Ref: 144 Red Hill Church Road
Dunn, NC 28334
Permit #2310-0057
Metal Framed Garage

The above location has been visited and we have determined that the garage framing coincides with the manufacturer plans in accordance with the 2018 NC Residential Code. The following corrections should be made to the footer on the rear of the garage.

TYP. FND. DETAIL

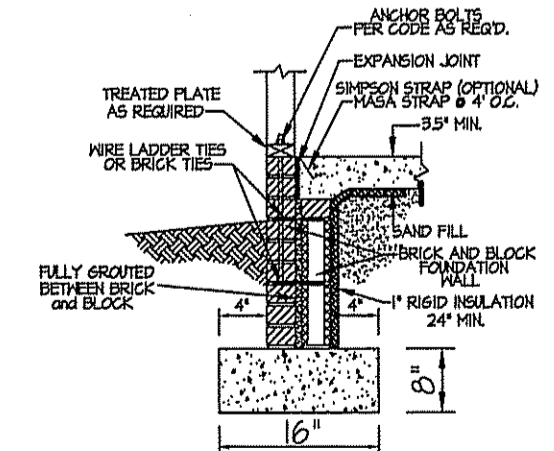
1. The footer is not acceptable as installed in the rear which allows for a weakened system. We recommend that the footer be over dug to provide for an 8"-10" footer that extends under the slab as we discussed. Install #4 rebar at 3 ft on center and connect 4" into concrete. This change is as discussed and meets final requirements so the project will be acceptable as built.
